Portishead Branch Line (MetroWest Phase 1)

Planning Inspectorate Reference: TR040011

9.3.3 ExA.SoCG-EA.D1.V1 – Statement of Common Ground

Date: November 2020

2.48 - Ashton Vale Road Pedestrian Ramp Design Plan

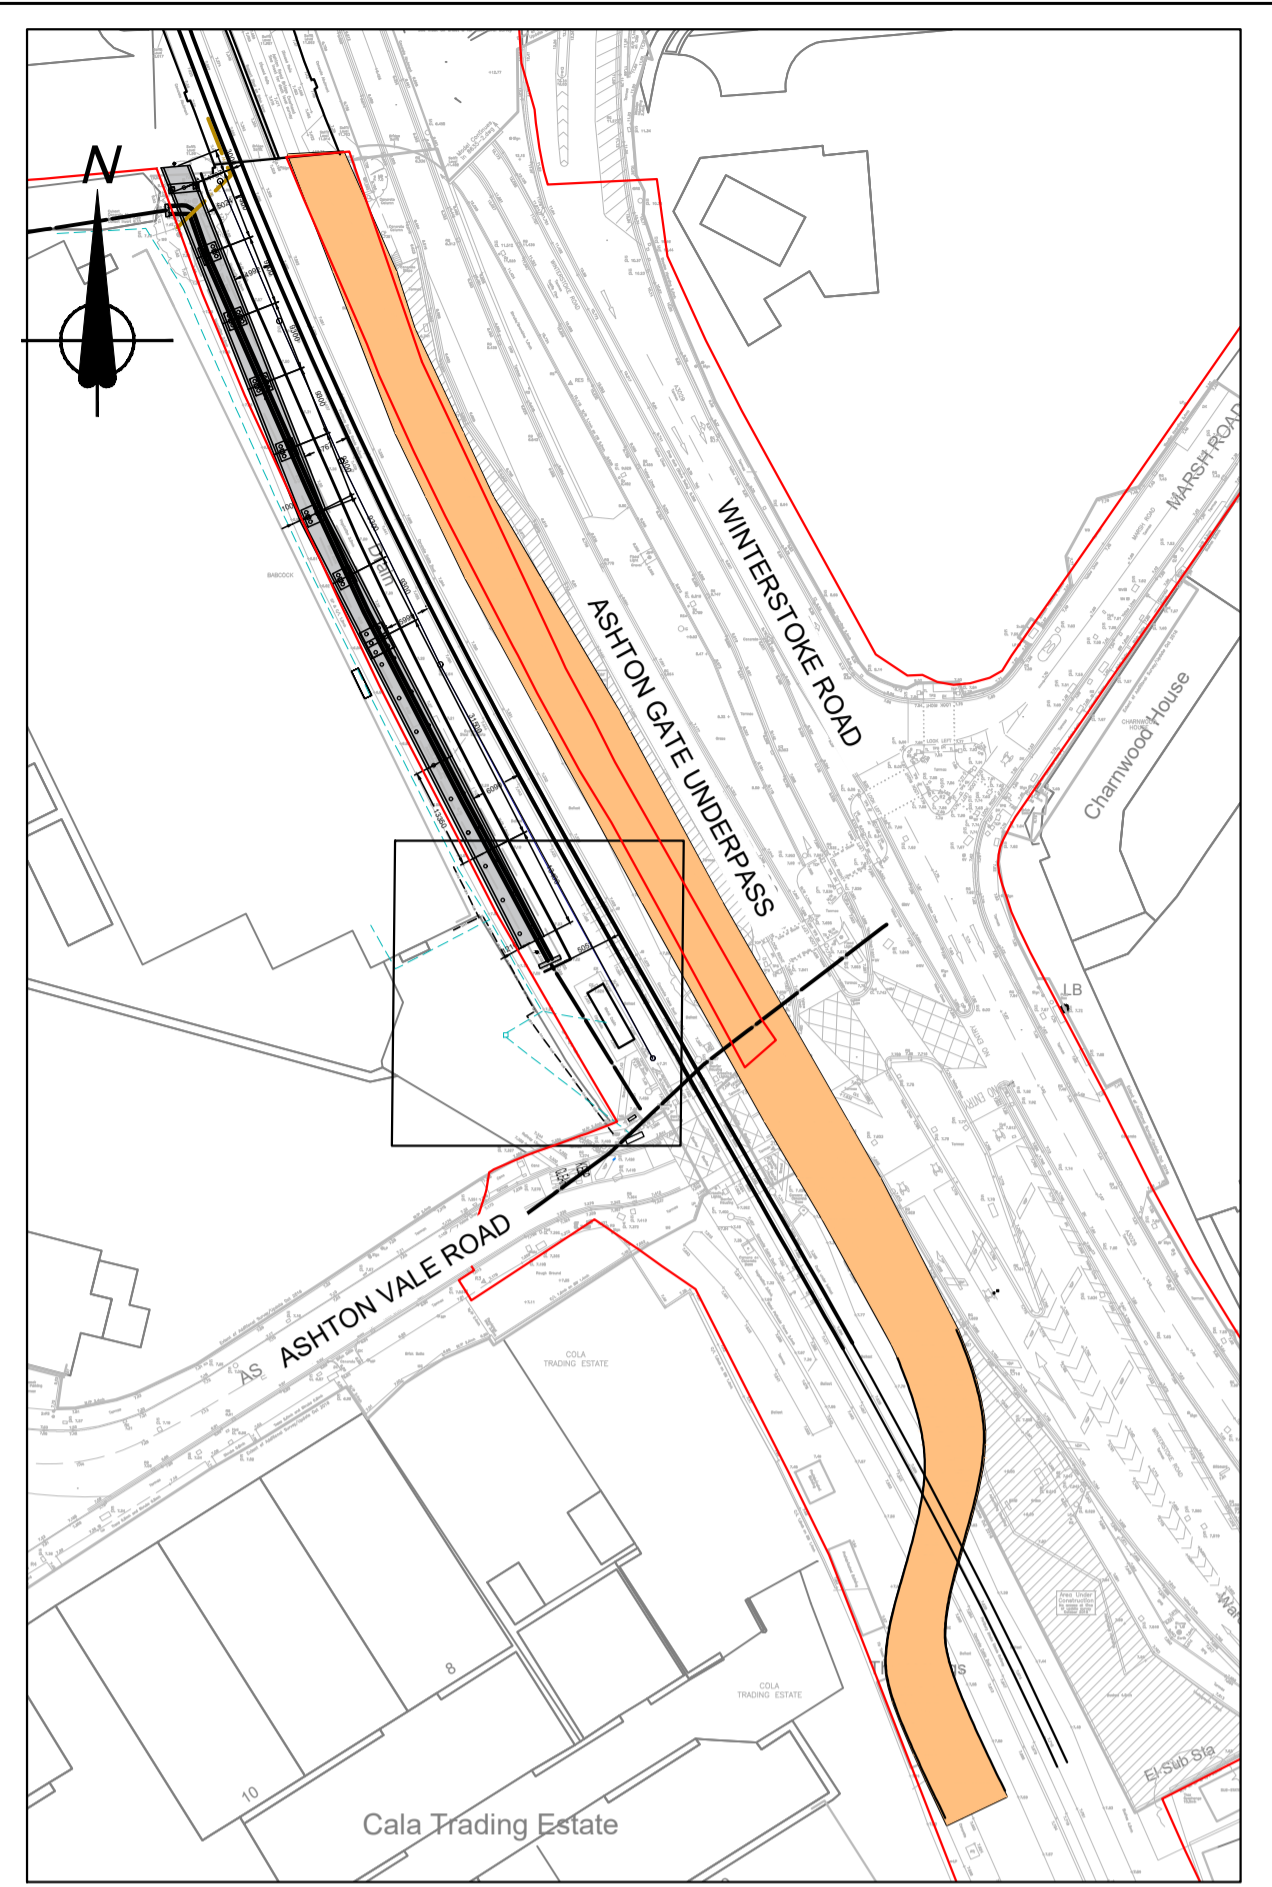
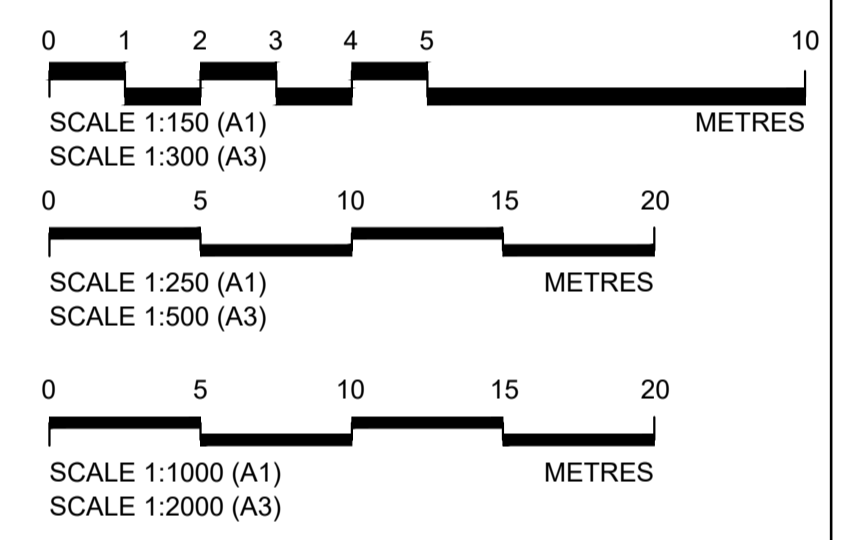
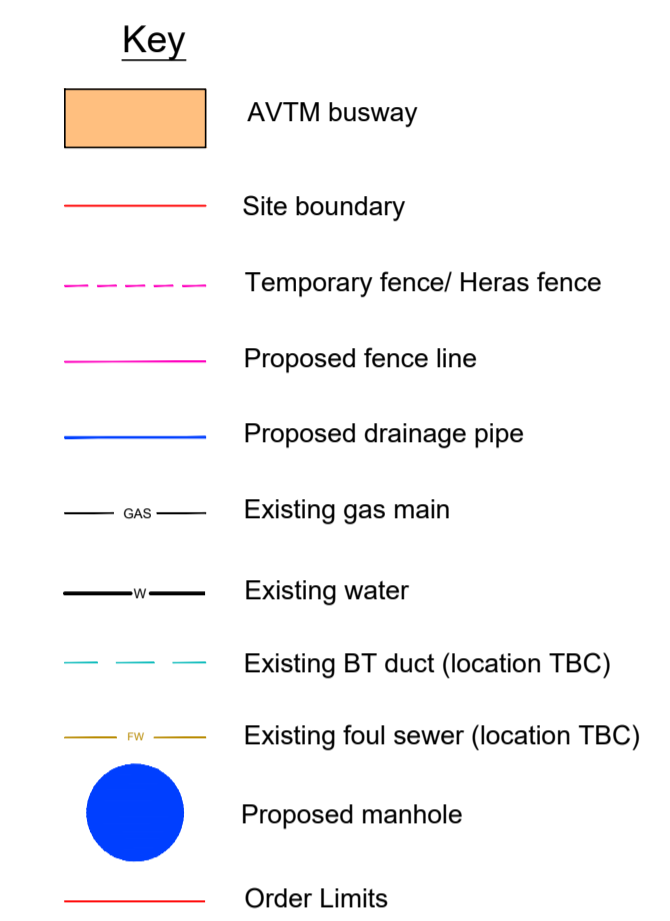
5.2.18	Floodplain compensation	Stated that if the model review is satisfactory, they would accept the compensation V5 being provided for the ramp, on the grounds that it would appropriately mitigate the increase in flood risk.	The Applicant is awaiting confirmation from the EA that they are satisfied with the ramp modelling.
